**PROJECT # 1001989**

**RE: Tracts C-2-A-1 thru C-2-A-3, Campbell Lands**

DATE: October 19, 2009  
TO: Jack Cloud, DRB Chair  
FROM: Catalina Lehner, Senior Planner *cll*  
RE: Project #1001989, Coors Car Lot

**SITE PLAN FOR BUILDING PERMIT**

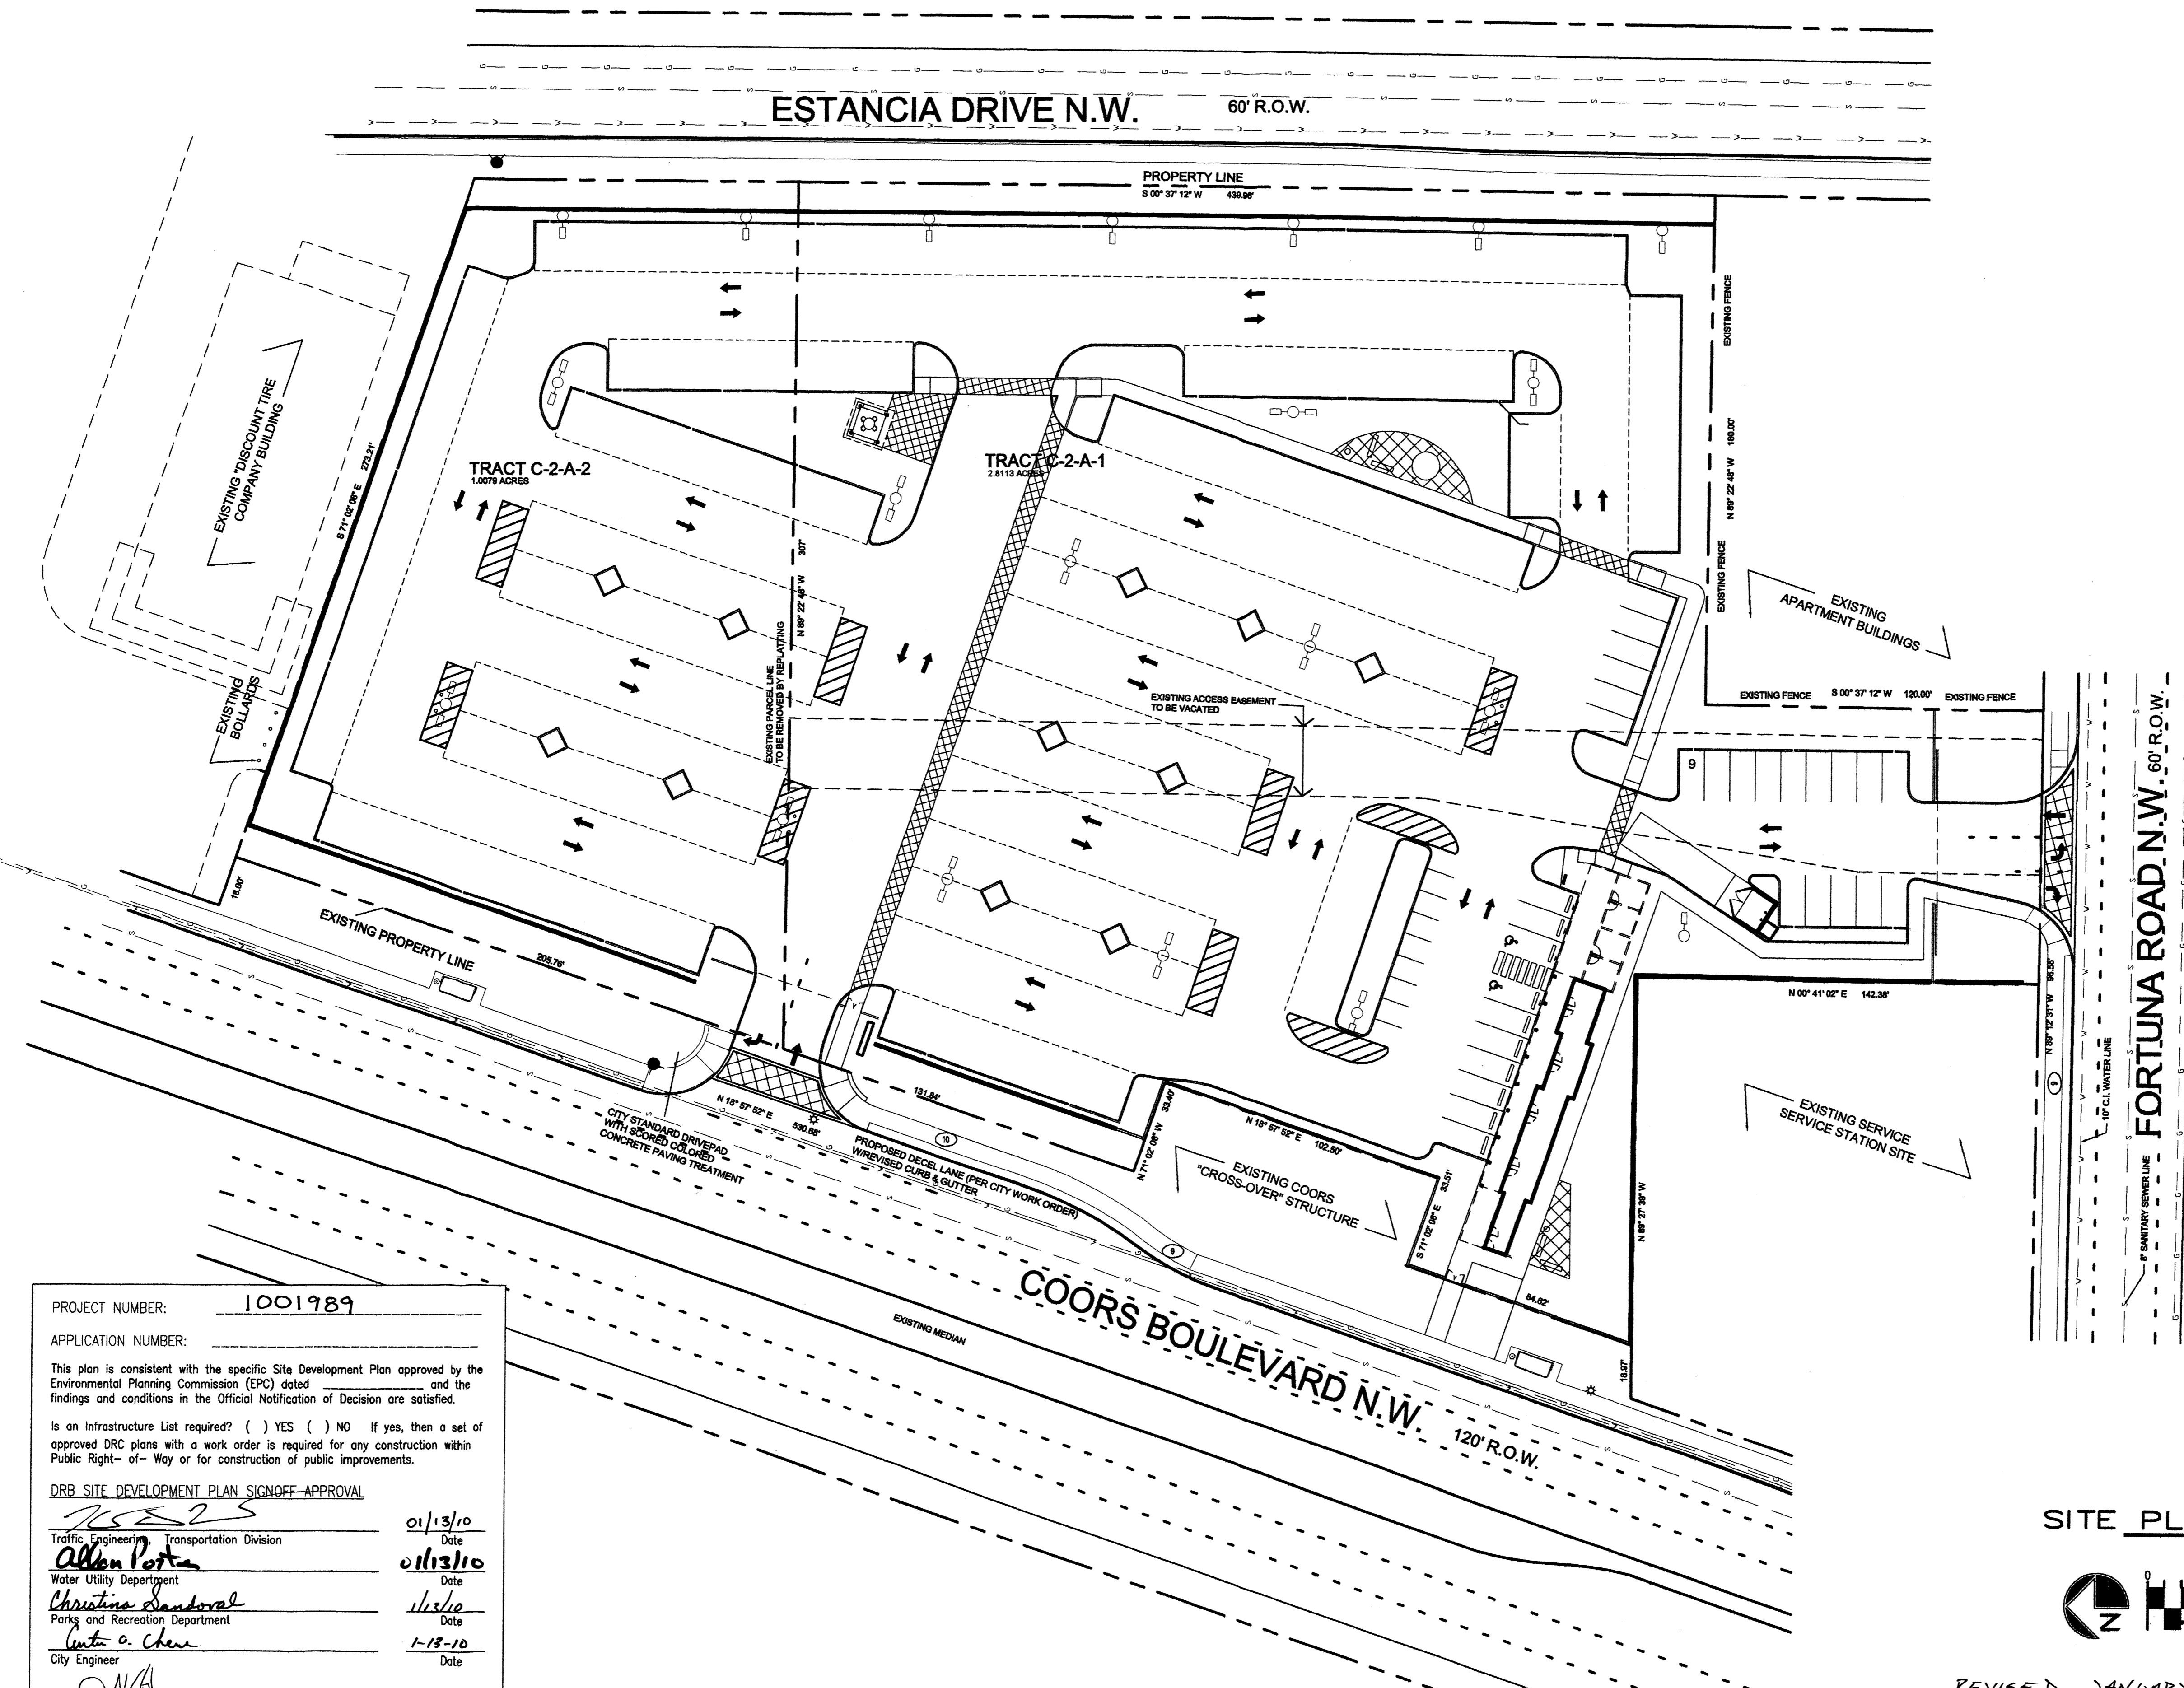
Condition 10B- Signage: (clarification) The note regarding electronic display panels should also be placed on Sheet 3 (the main spbp sheet).

Condition 11- Utilities: (clarification) The utilities note is not found on Sheet 6 as stated in the change letter. Rather, it's found on sheet 3 (the main spbp sheet). If desired, this note could be placed on Sheet 6.

**4E CURB NOTCH**  
NOT TO SCALE

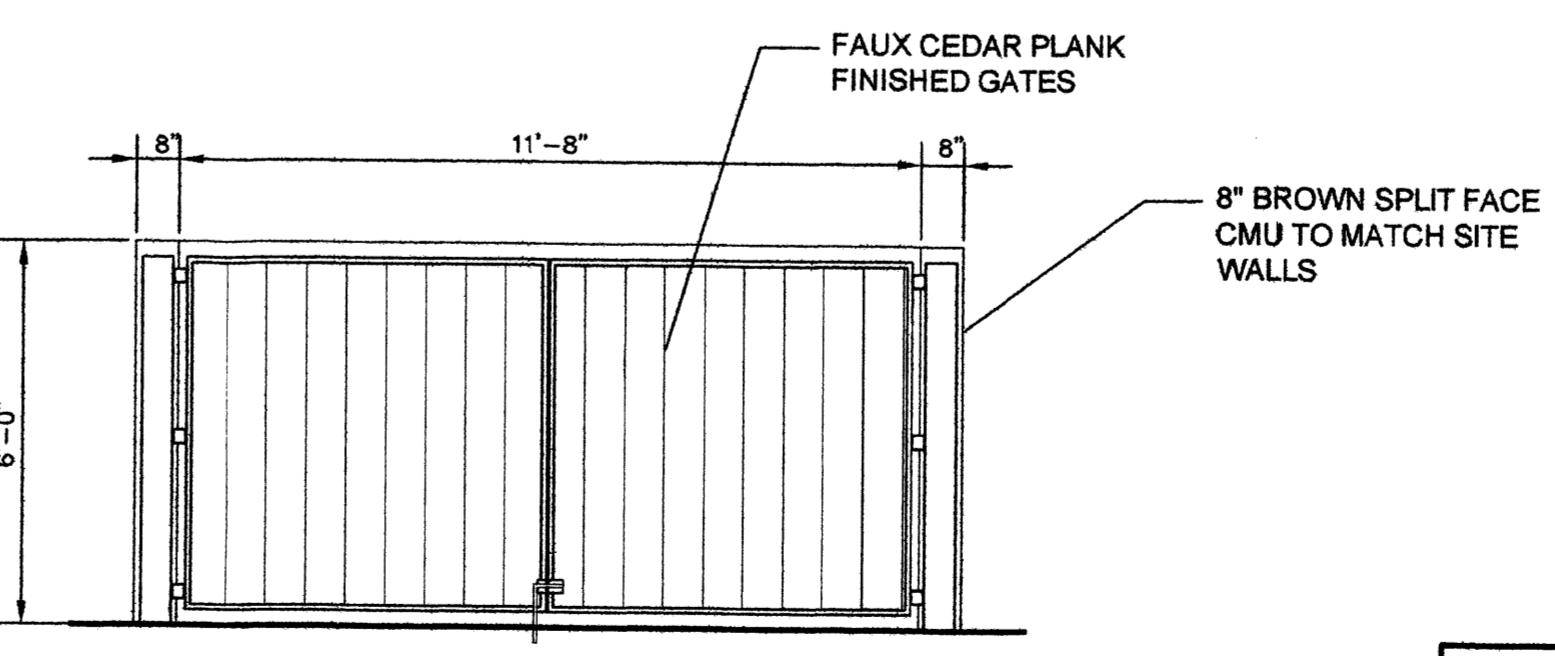
Condition 9A- Sustainability/Water Harvesting: The curb notches are shown in appropriate locations. However, a keyed note needs to designate each curb notch. Without the note, the fact that the lines do not connect could be misunderstood as an error in the drawing.

**A PROPOSED PLAN FOR  
COORS PARK & SELL**  
(COORS BLVD. N.W. AND FORTUNA RD. N.W.)  
ALBUQUERQUE, NEW MEXICO

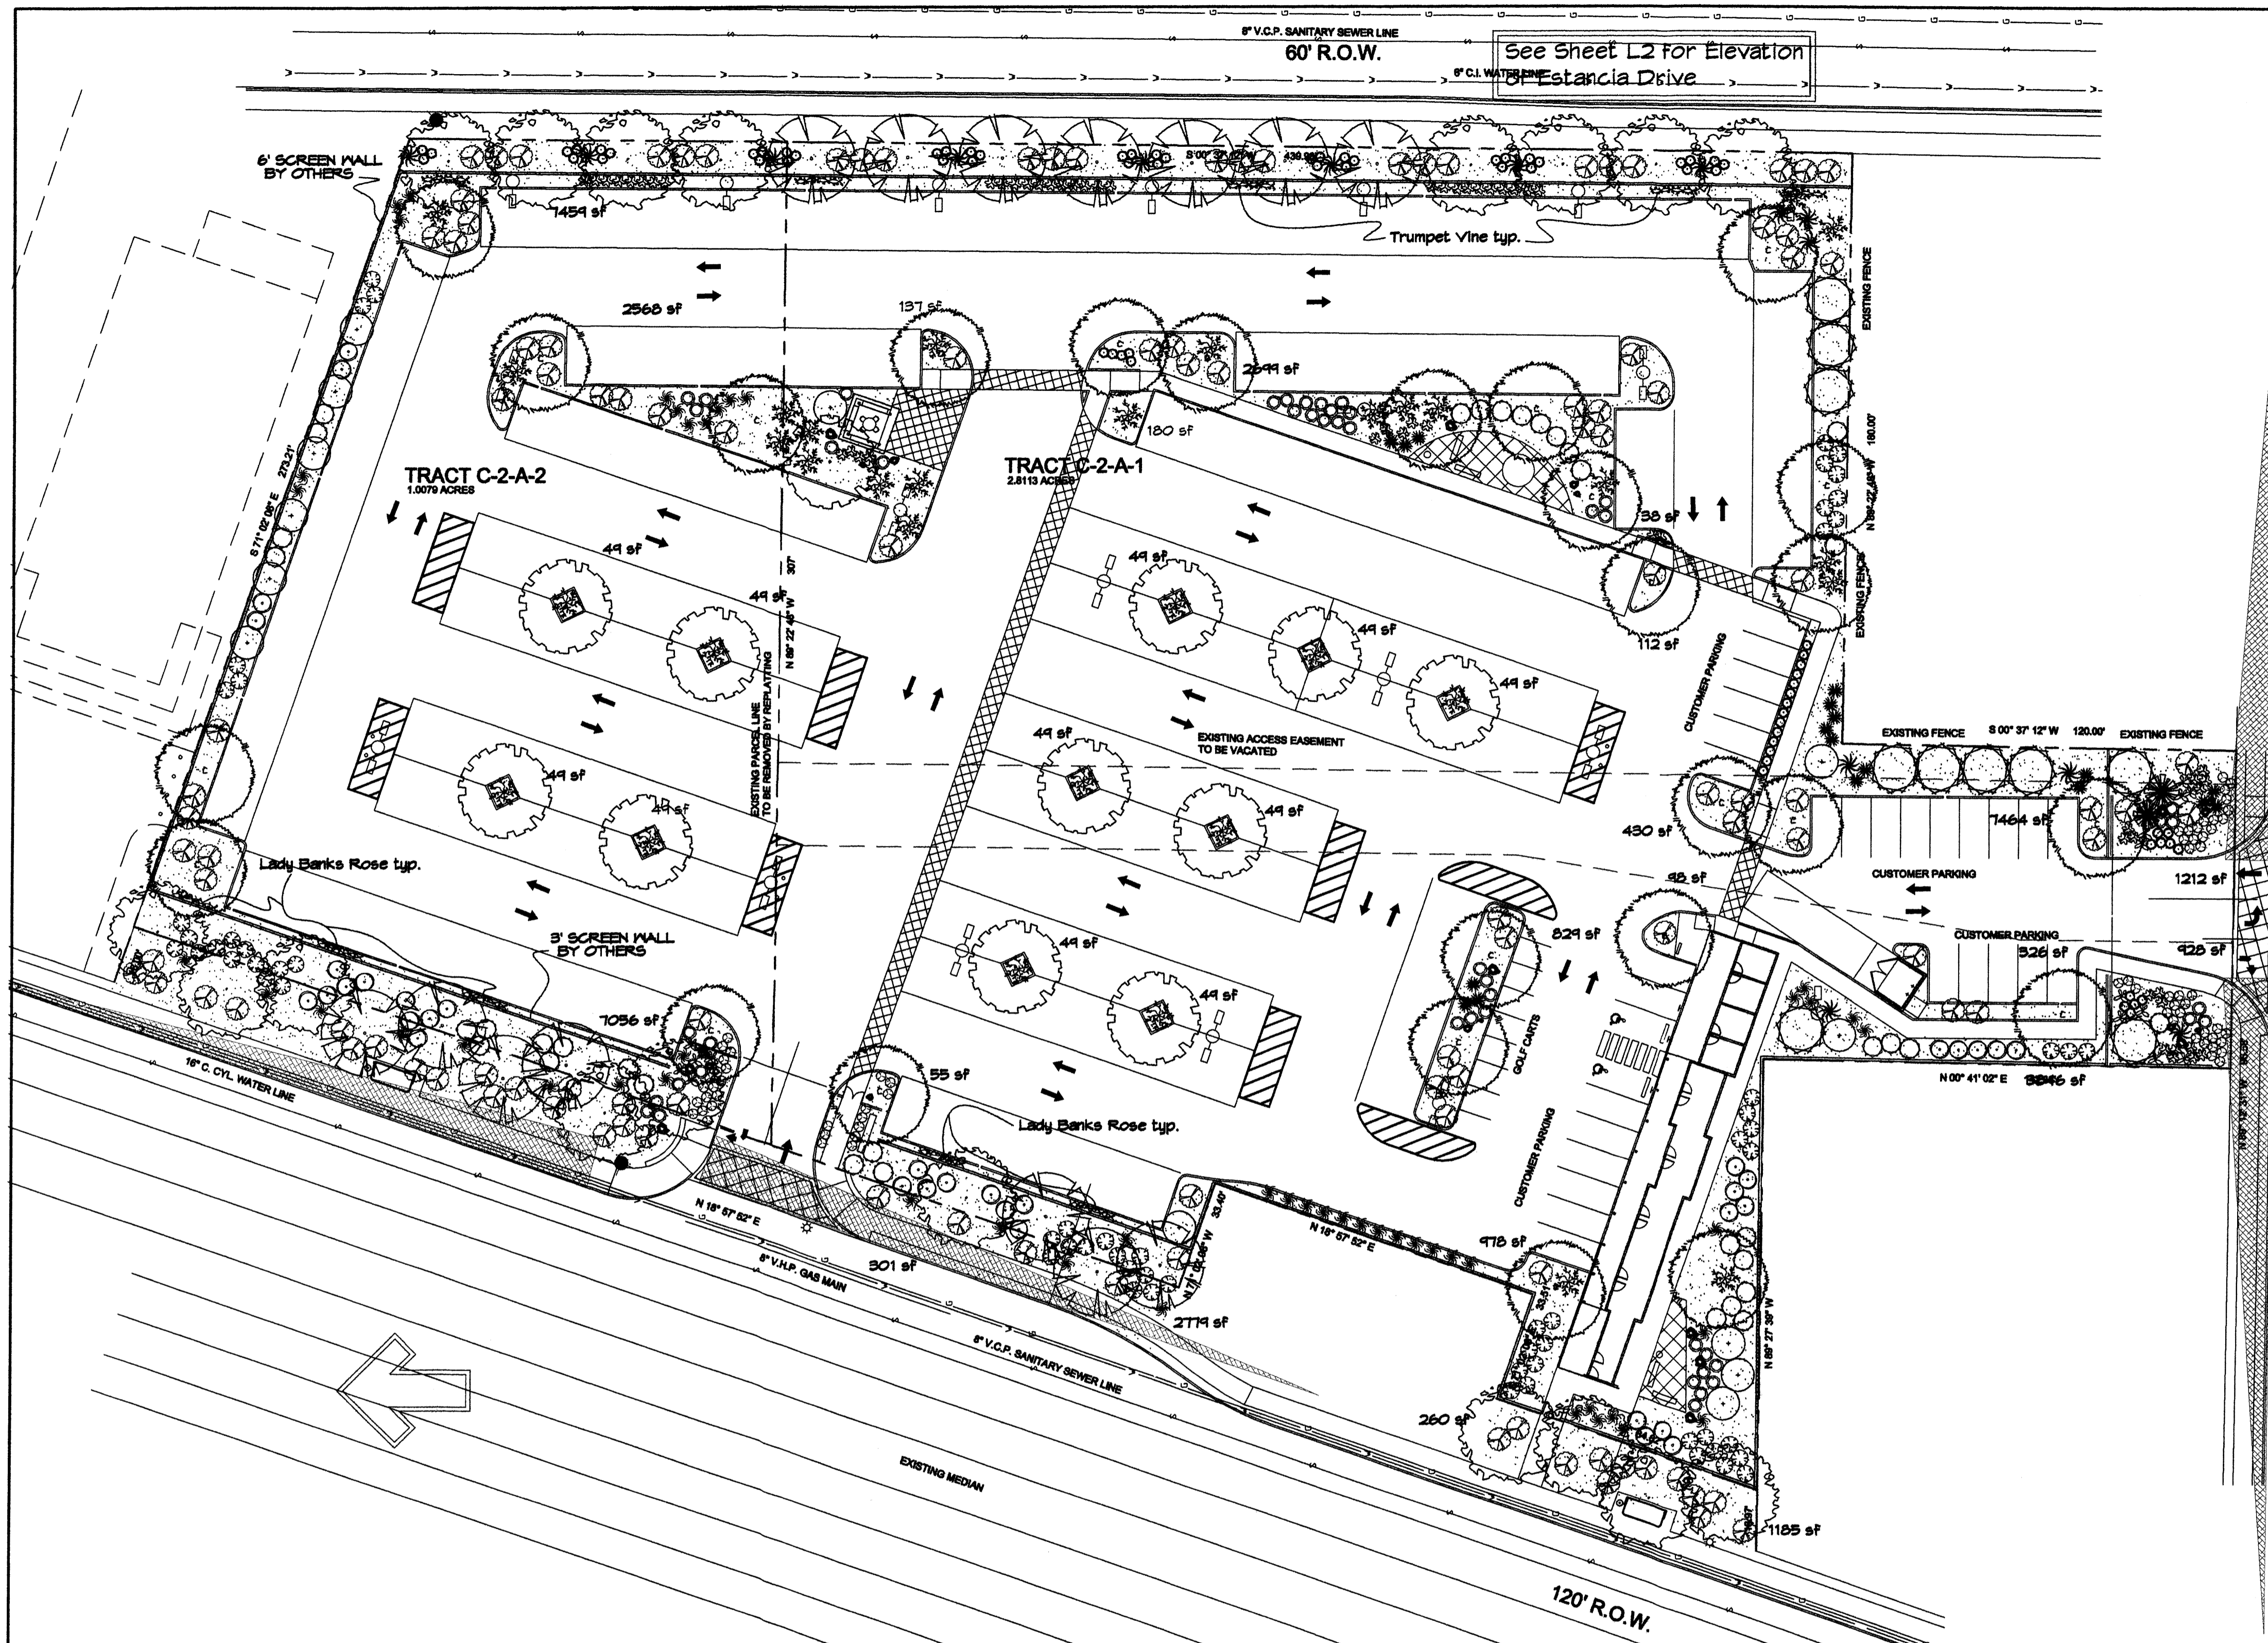
Autumn Blaze Maple is not on this list. The Forrester considers Autumn Blaze Maple a good tree for people's private yards, but not for commercial applications. This tree needs a lot of water and does not perform well near a lot of asphalt. A more appropriate choice would be Chinese Pistache, which also turns reddish in the Fall.
